Sheringham Shoal Offshore Wind Farm Extension Project and Dudgeon Offshore Wind Farm Extension Project

Written Submission on behalf of National Grid Electricity Transmission Plc

Deadline 5 (13 June 2023)

Sheet 39 of 40

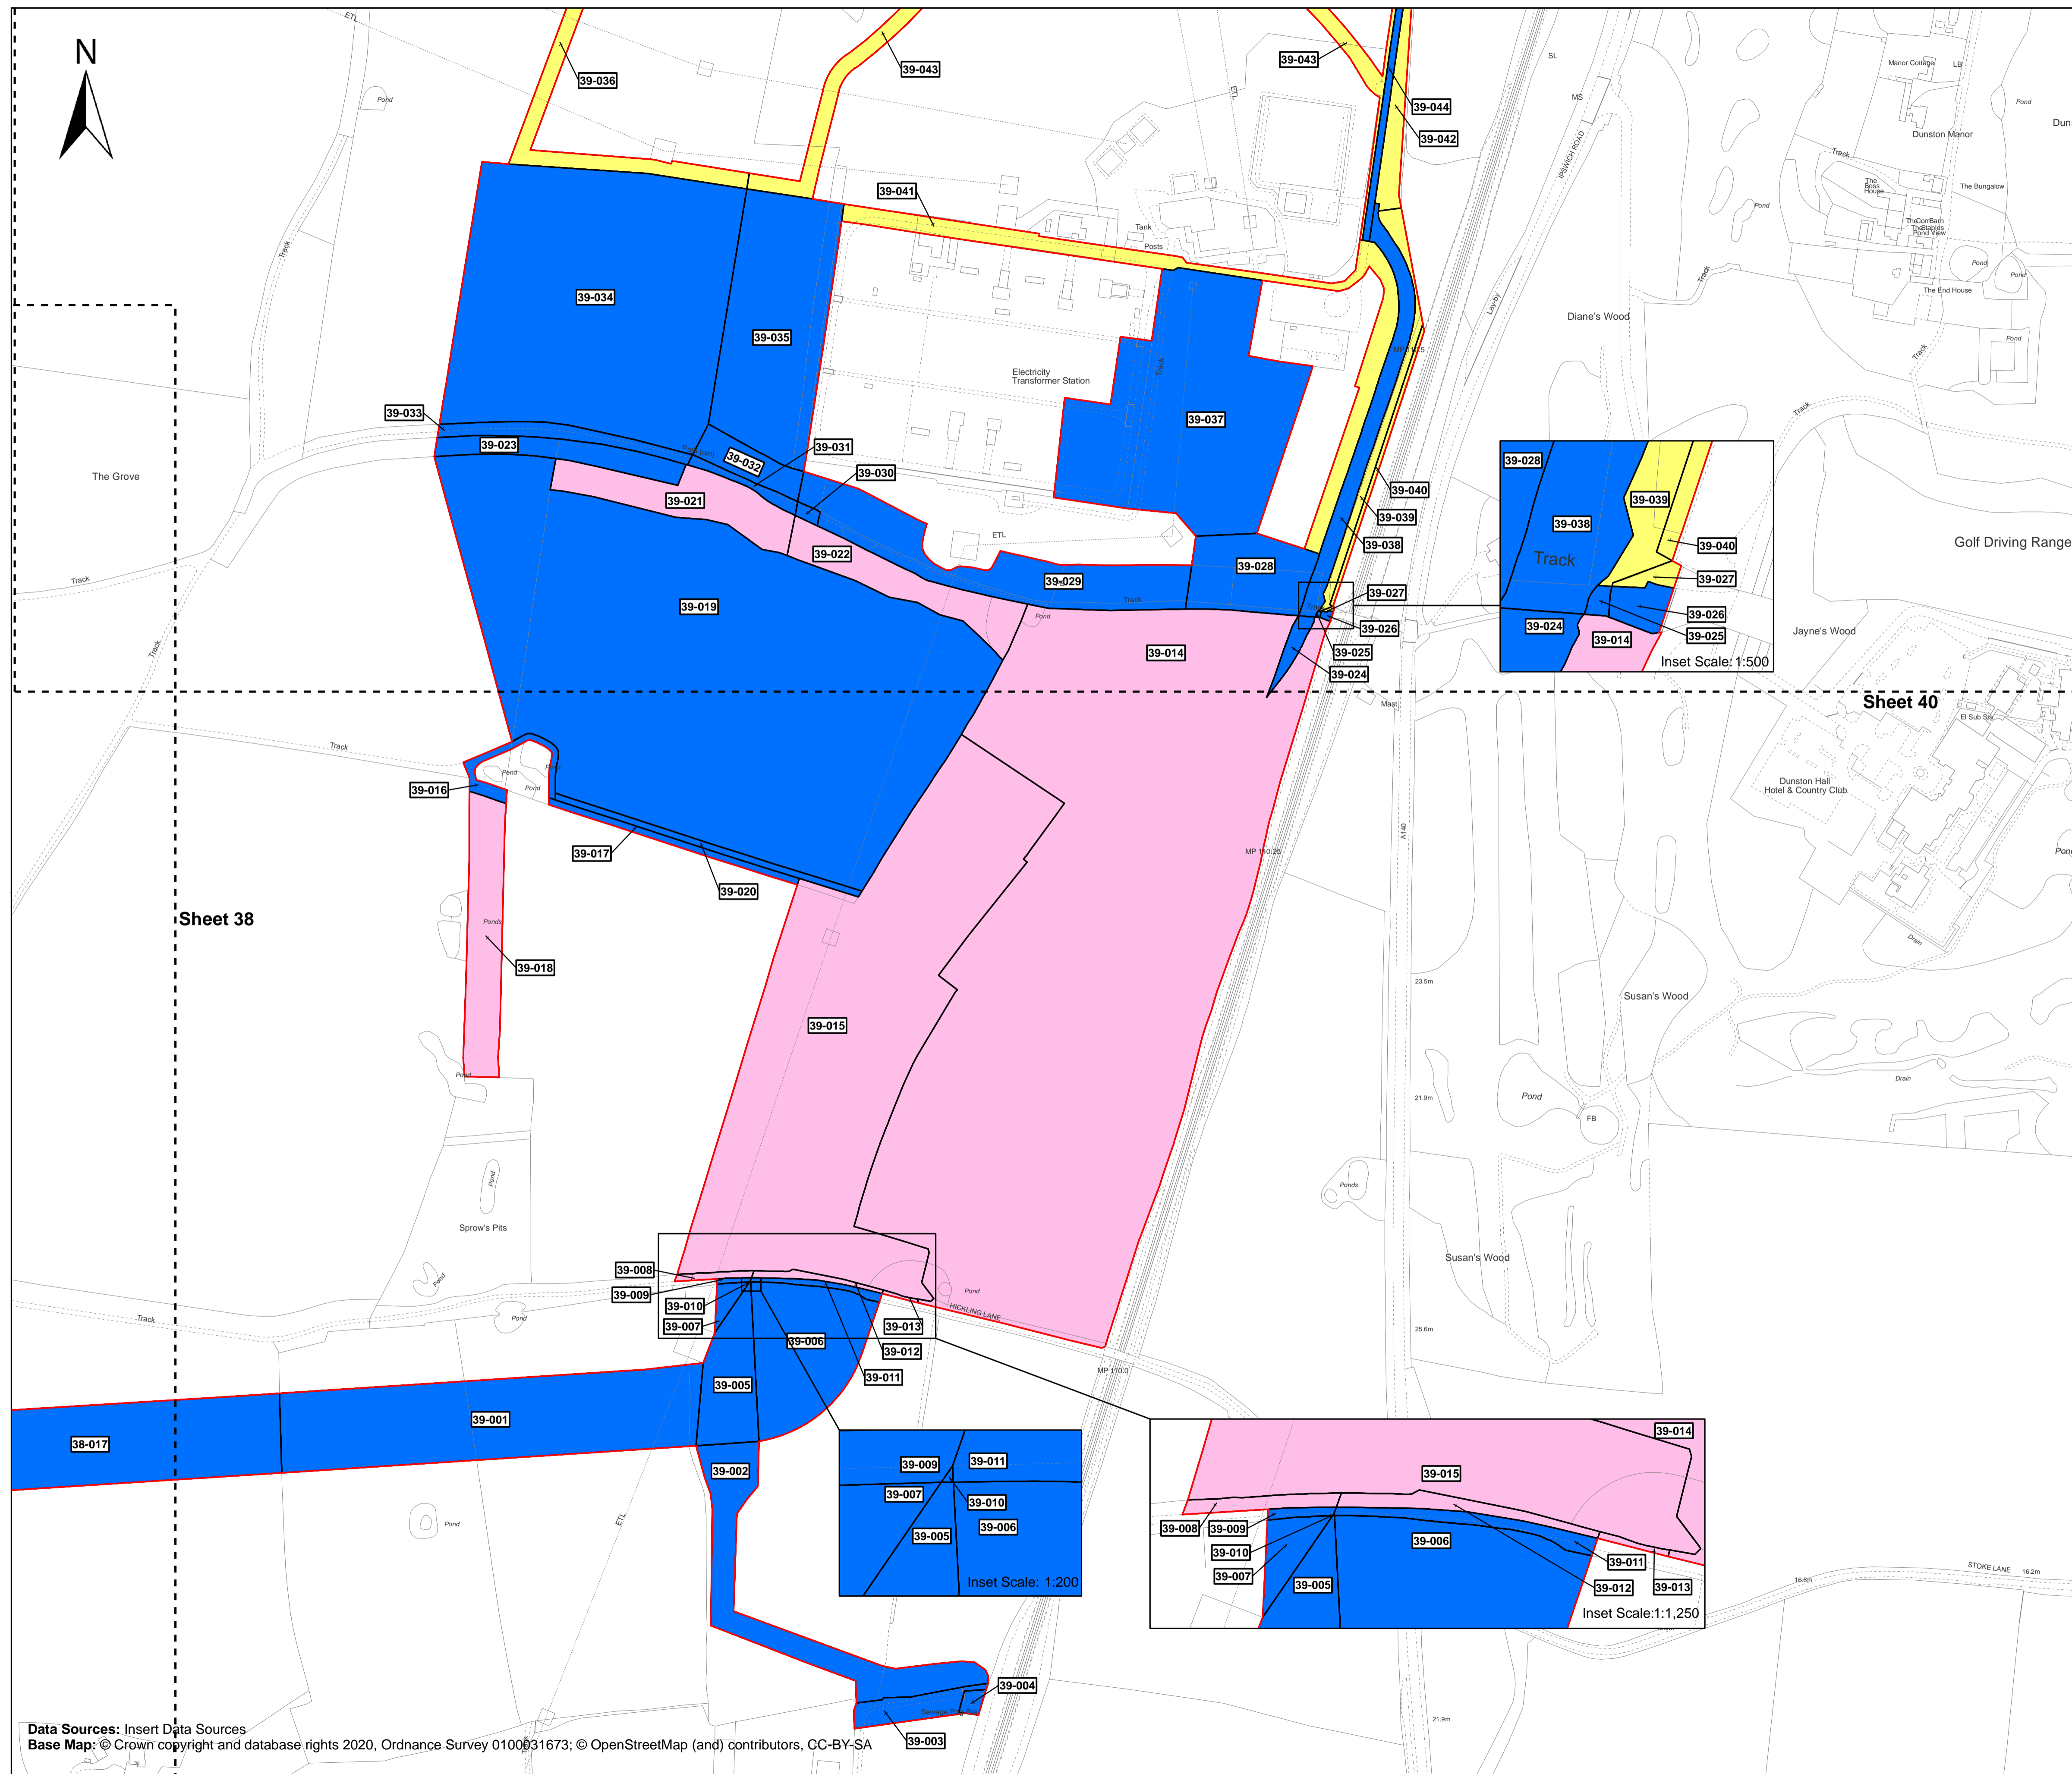
- 4 NGET remains particularly concerned that both the Book of Reference (Revision E) and the Land Plans (Revision C) continue to show both the temporary occupation and use and the permanent acquisition of rights in Plots 39-032, 39-034, 39-035 and 39-037, each of which is immediately adjacent or proximate to the Substation and are highly likely to be required by NGET in relation to the planned extension of the same. An extract from Sheet 39 of the Land Plans is included below:

- 5 Whilst NGET recognises that the Applicant needs to ensure that sufficient rights are acquired to enable its planned connection to the Substation (referred to elsewhere as the 'National Grid substation connection works'), the extent of temporary possession powers and rights being sought is entirely disproportionate to the nature of the works required to be undertaken. Indeed, NGET considers that the exercise of those powers and acquisition of those rights could materially impact upon the delivery of its planned Substation extension and, in turn, hinder the effective discharge by NGET of its statutory duties at a critical location in the electricity transmission network.
